**REQUEST**

Current Zoning: N1-A (Neighborhood 1)  
 Proposed Zoning: R-8MF(CD) (Multifamily Residential, Conditional)

**SUMMARY OF PETITION**

The petition proposes to develop a vacant parcel with 70 single family attached residential units and accessory uses.

SCHEMATIC SITE PLAN

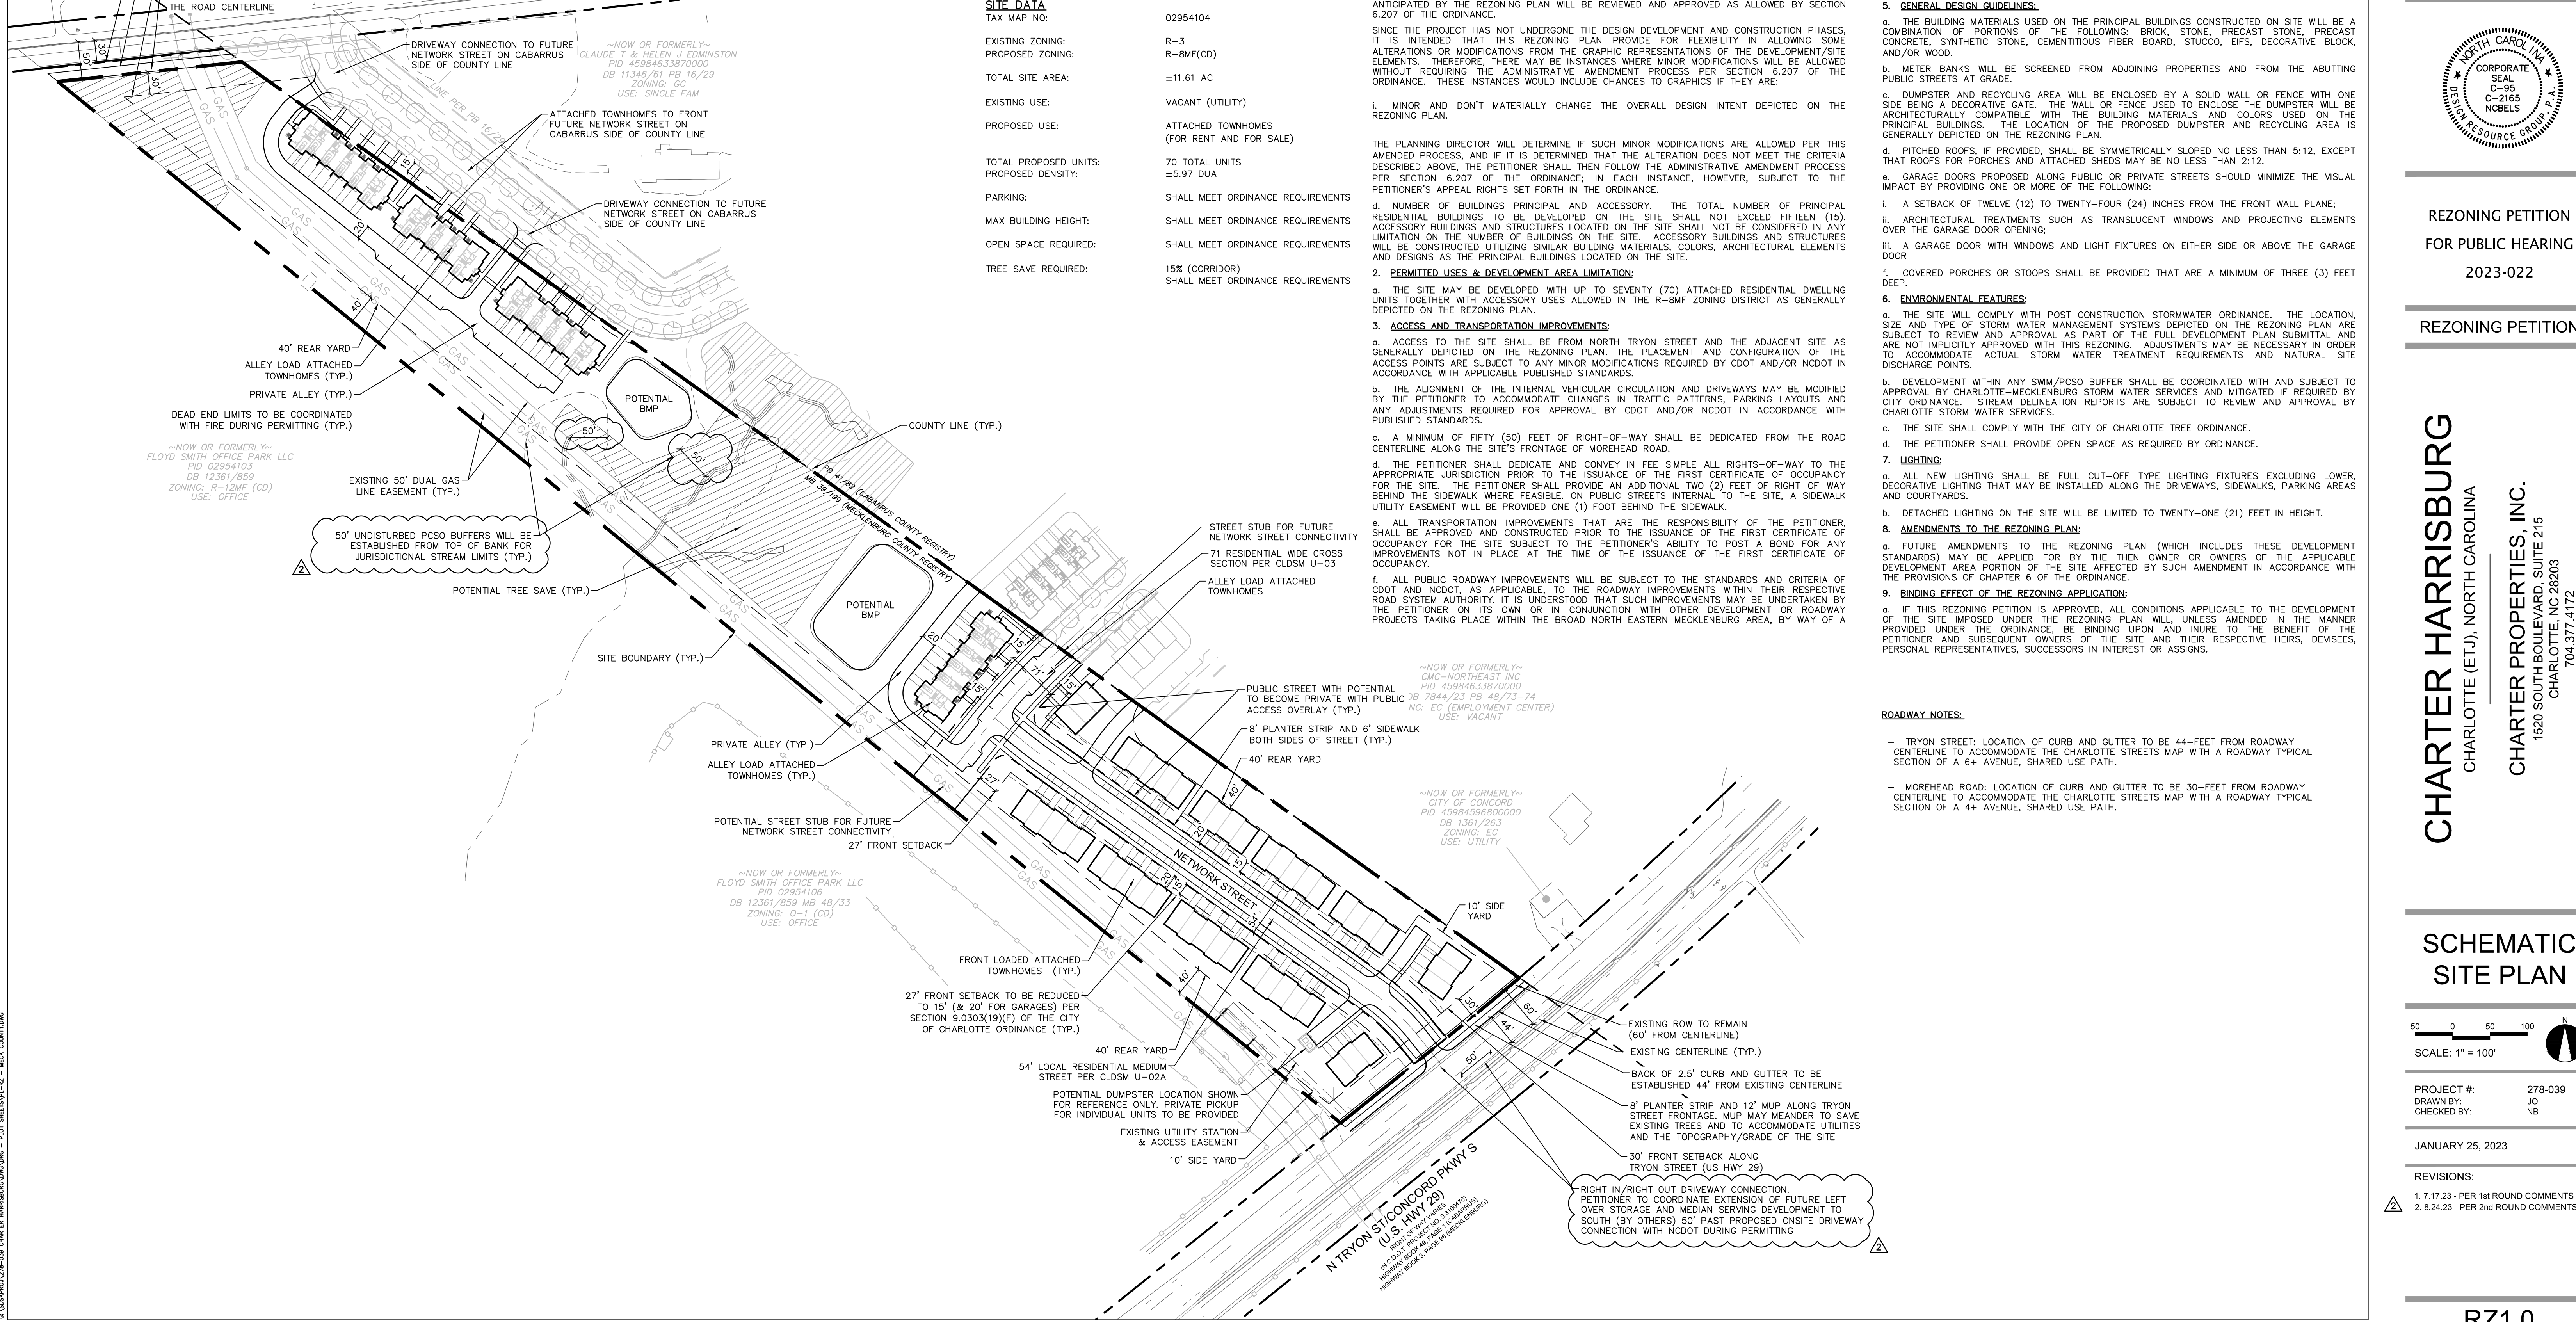
1. Revise site plan and conditional notes to commit to removing the Tryon Street access point in coordination with NCDOT.

2. Revise note regarding 50' undisturbed stream buffers to delete the second sentence stating "Final buffer limits will be based on confirmed jurisdictional limits after draining of pond and final impact limits that are pursued."
